Subject: File # CAO19-015 Comments

I wish to comment on File # CAO19-015/ Permit Type III.

PAVING AND GRADING PLAN & PROFILE

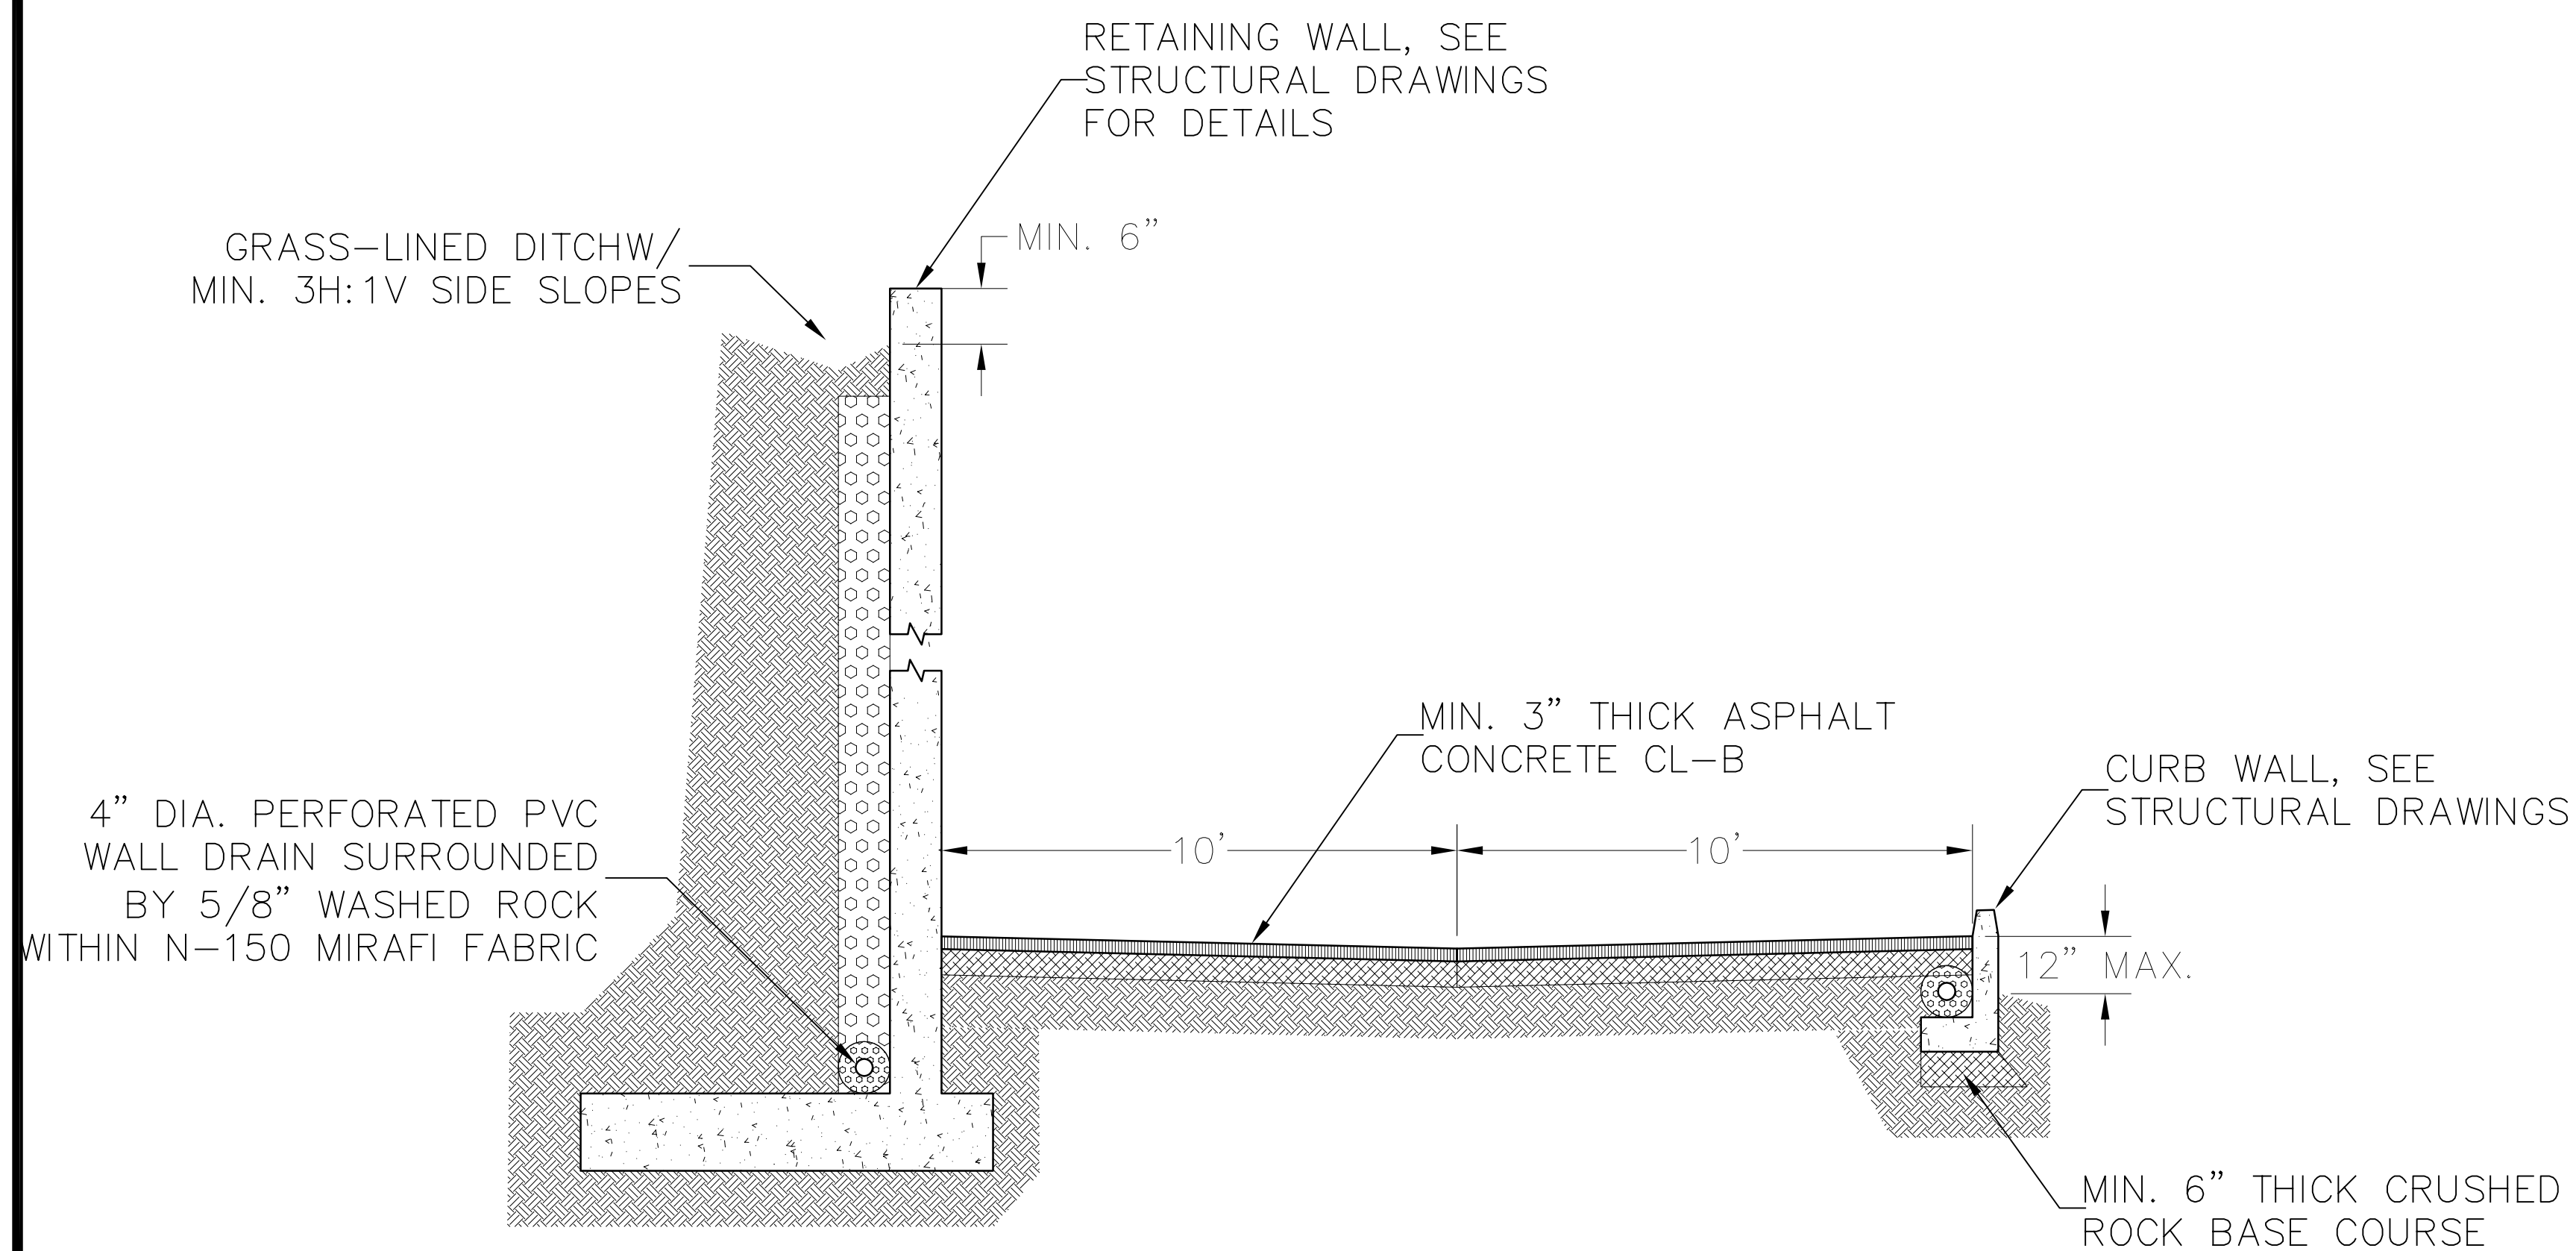
- The south end of the rockery on the west side – the drawing shows a non-linear wall and an apparent step that appear inaccurate and perhaps implies inaccurate surveying
- The property line on the north side of the proposed development is not clearly shown
- Trees targeted for removal are not easy to identify, and it is not clear if all impacted and nearby trees are shown.

There is an apparent Ecology concrete wall proposed on the upslope side of the development to intercept offsite drainage. Ecology blocks are typically 2' x 2' x 6' eyesores. The placement of these blocks appears to be along a steep slope (identifying the planned location at the site is not clear with the inaccuracies in references like the rockery and the lack of a clear property line). Founding an ecology block on a steep slope is at best risky and at worst will result in failure (settling and tipping) over time, well after the developer is no longer available for corrective measures. It will require significant excavation into the steep slope to a depth likely to impact the roots of trees it is shown upslope of, resulting in stress on those trees, which are valuable to the neighborhood. It also appears that the block wall would require removal of several 8 – 10 inch shading maple trees. Use of ecology blocks in this setting should be scrutinized for all of these reasons. I included two pictures showing the steep slope where ecology blocks are proposed below.

Reducing the width requirement will allow preservation of several beautiful, mature cherry trees, reduce the stress on the significant fir tree on the south side of the proposed roadway development, and reduce the height of the proposed concrete retaining wall. The proposed retaining wall will be a significant visual degradation compared to the current woodland landscaping. The city has the opportunity to retain a special collection of cherry trees and woodland

RETAINING WALL & CURB WALL
WHERE APPLICABLE

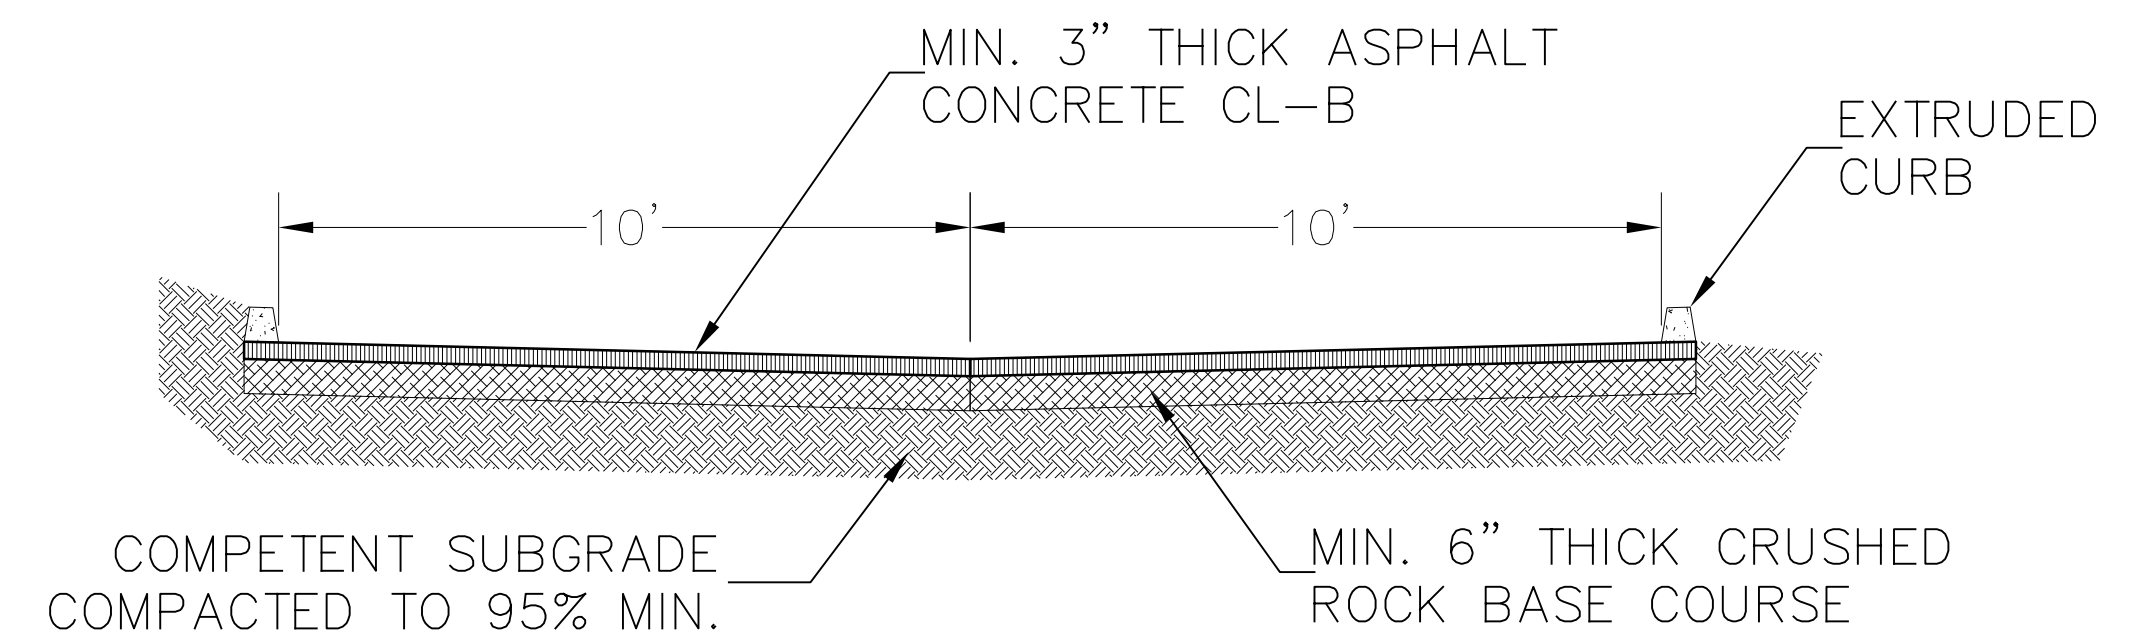
Removing the mature cherry trees and associated salal, ferns, seasonal wildflowers, and other natural woodland plants, and installing a concrete retaining wall up to 8 feet tall would result in visual and habitat degradation, and food source removal. To illustrate the current pretty area that is proposed for destruction, I included pictures of the current condition, showing some of the trees and vegetation that would be removed.
